Our reference: DOC14/223986-02

**Resource Recovery Facility, Kembla Grange (SSD 5300)
Exhibition of Environmental Impact Statement – Submission from NSW EPA**

**Environment Protection Authority Submission
Resource Recovery Facility, Kembla Grange (SSD 5300)**

Statistical Ambient Noise Levels Bardess Crescent Friday 21 February 2014

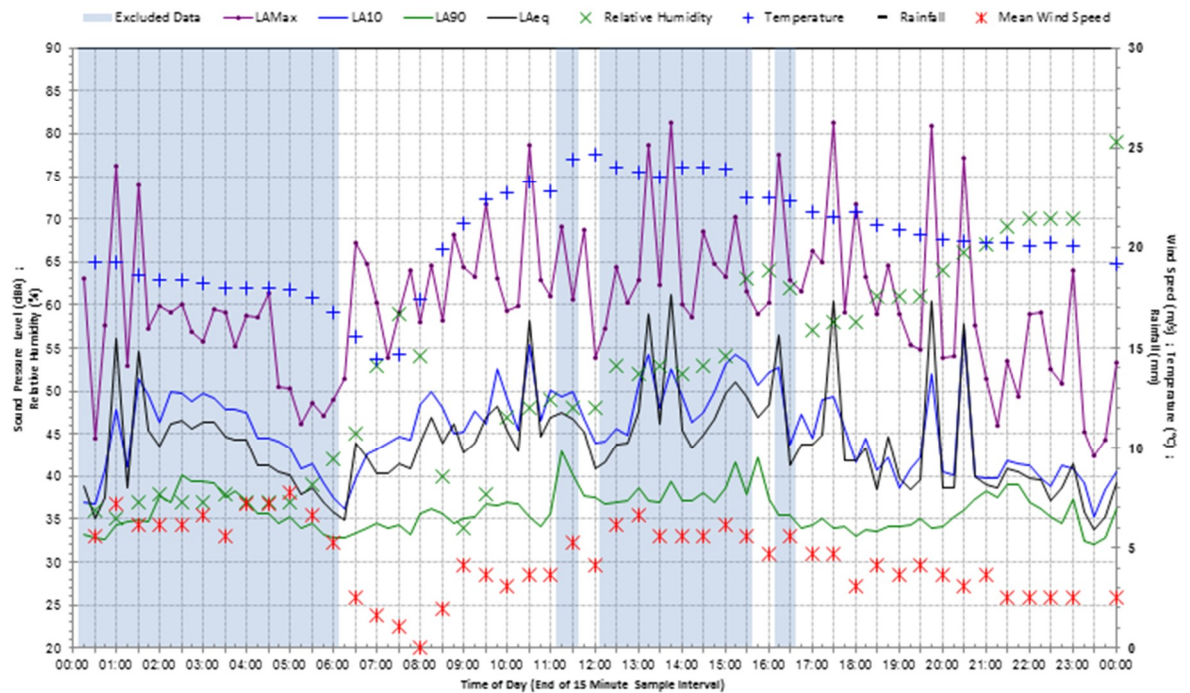
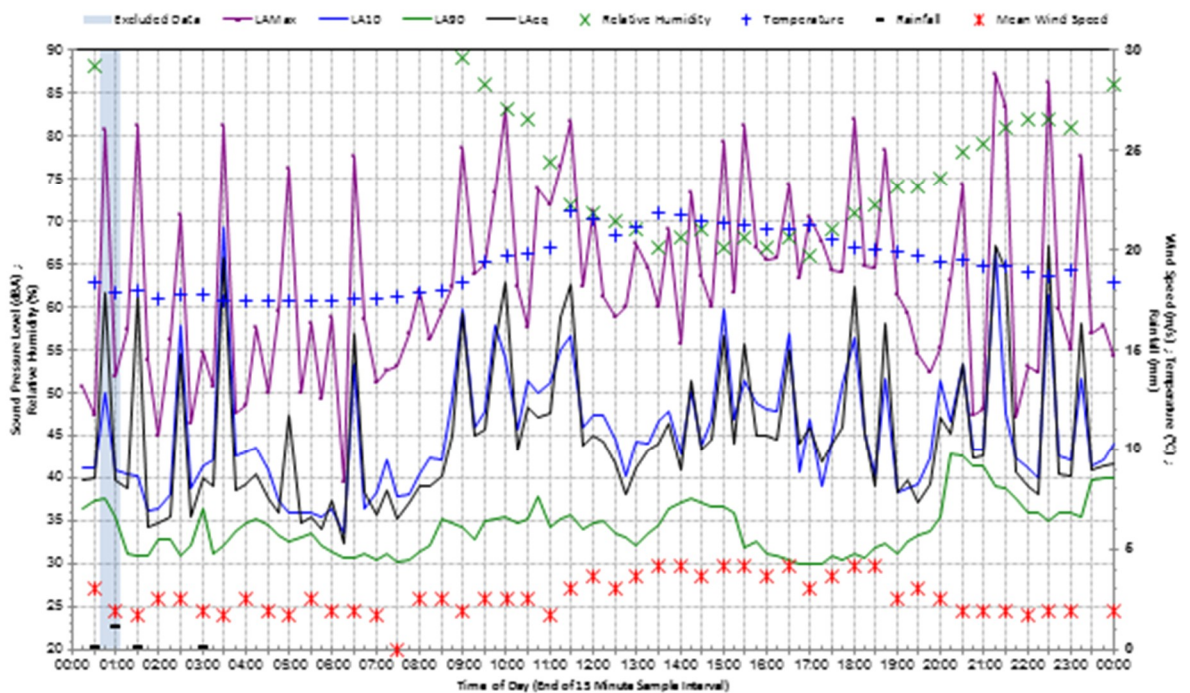
Background noise measurement data did not appear to be excluded from calculation of the Rating Background Level during some identified periods of rainfall. The reason for this was not explained in the NA, but it may have resulted in elevated RBL results due to the inclusion of periods where rainfall affected the background noise level. For example, the following night time Assessment Background Levels (ABL) for Bardess Crescent, presented in the NA, may have been reduced if all periods of rainfall were excluded from analysis:

- Friday 21 February 2014, ABL 30.9 dBA. Non-excluded periods of rainfall LA90(15min) 31, 36 and 37 dBA (from graphed data in NA); and
- Saturday 22 February 2014, ABL 31.1 dBA. Non-excluded periods of rainfall LA90(15min) 32 and 33 dBA.

Statistical Ambient Noise Levels Bardess Crescent Sunday 23 February 2014

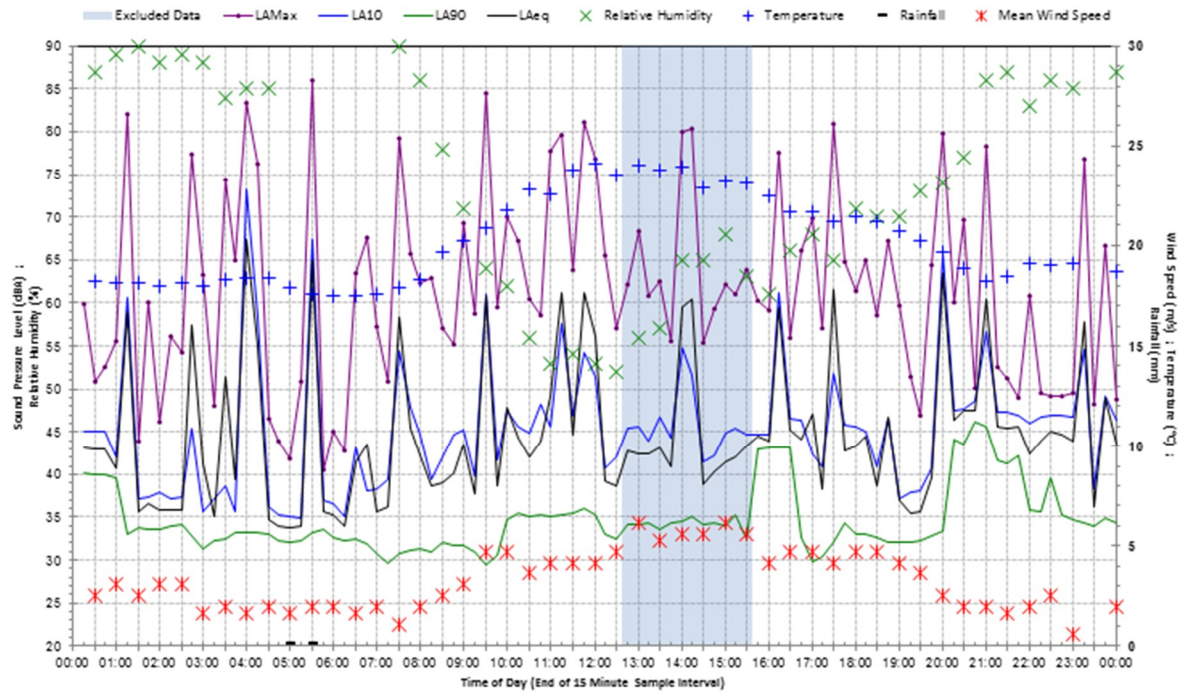
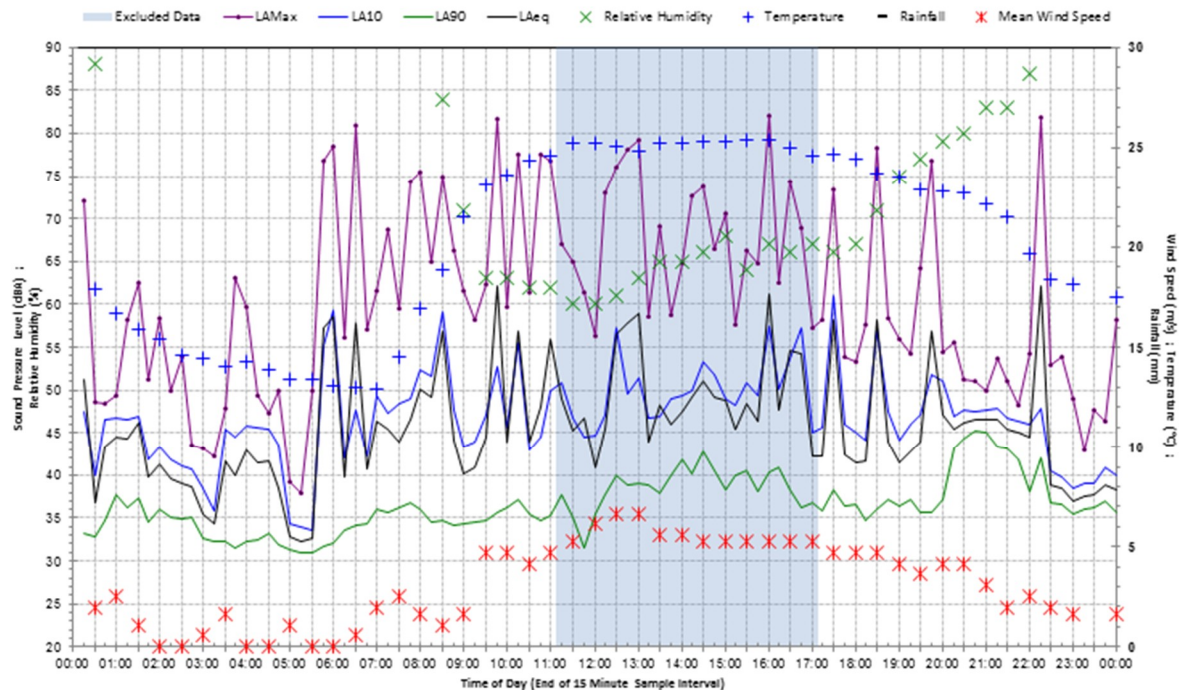
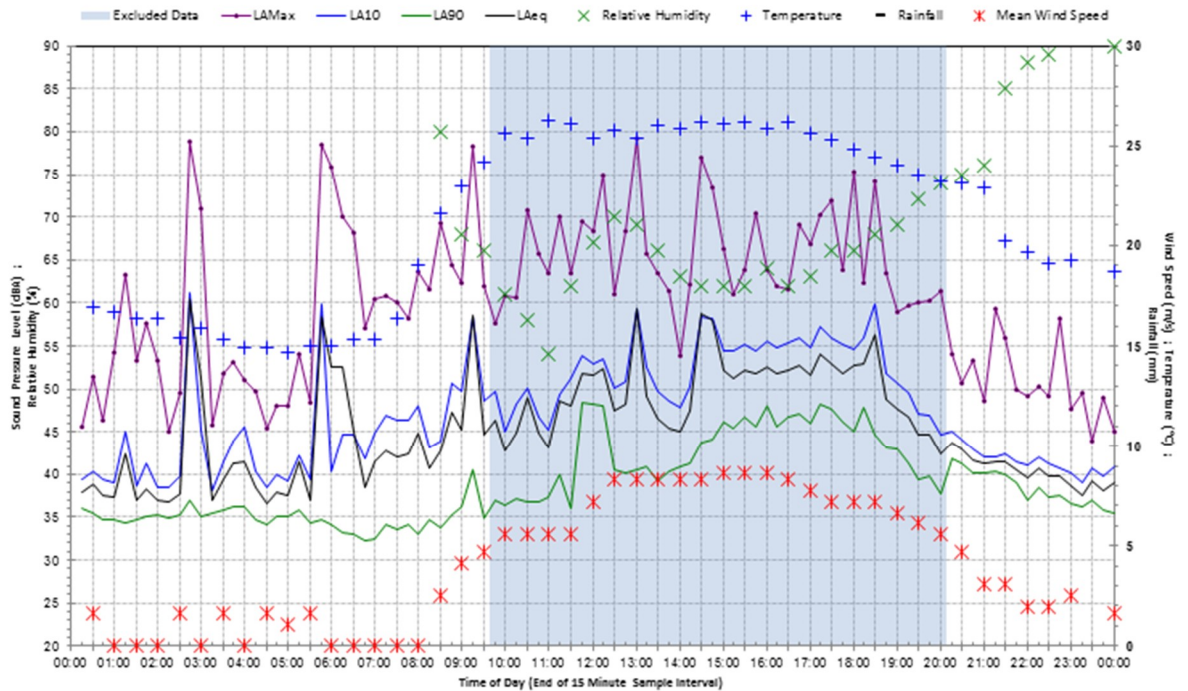
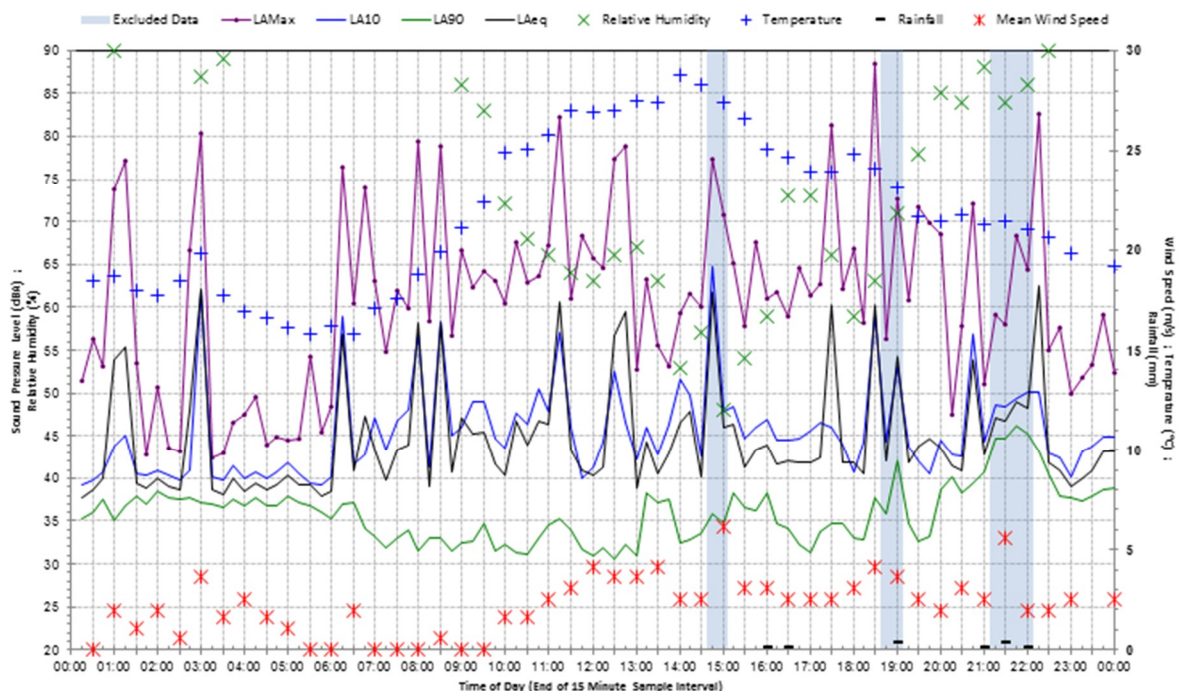
The OEH data indicate that F and G class stability category conditions were present for part or all (between 22% and 100%) of every night during the monitoring. Three of the four highest measured ABLs, for 25/02/2014 to 27/02/2014, were for the only nights where OEH data indicate that F and G class stability category conditions were present for the entire night time period. This indicates that the background noise level increases during temperature inversion conditions.

The monitoring location at 6 Bardess Crescent, Farmborough Heights, appears to be under conifers or pine trees, and attended monitoring summarised in the NA noted “some noise from the native fern nursery” which is operated at the monitoring location. The influence of nearby sources, such as the nursery, on monitoring results indicates that they may not be representative of the noise environment at other residences in Farmborough Heights.

Maximum noise events during the night time on the plots provided in the NA (for 6 Bardess Crescent) correlate well with ARTC timetables for the branch line between Moss Vale Junction and Unanderra, indicating that rail passbys (coal, grain and minor loads) are likely to be responsible for most night time maximum noise events. However, rail passbys appear to have little impact on the LA90 level at that location, so are unlikely to be the main reason for the higher than previously measured RBL at night time.
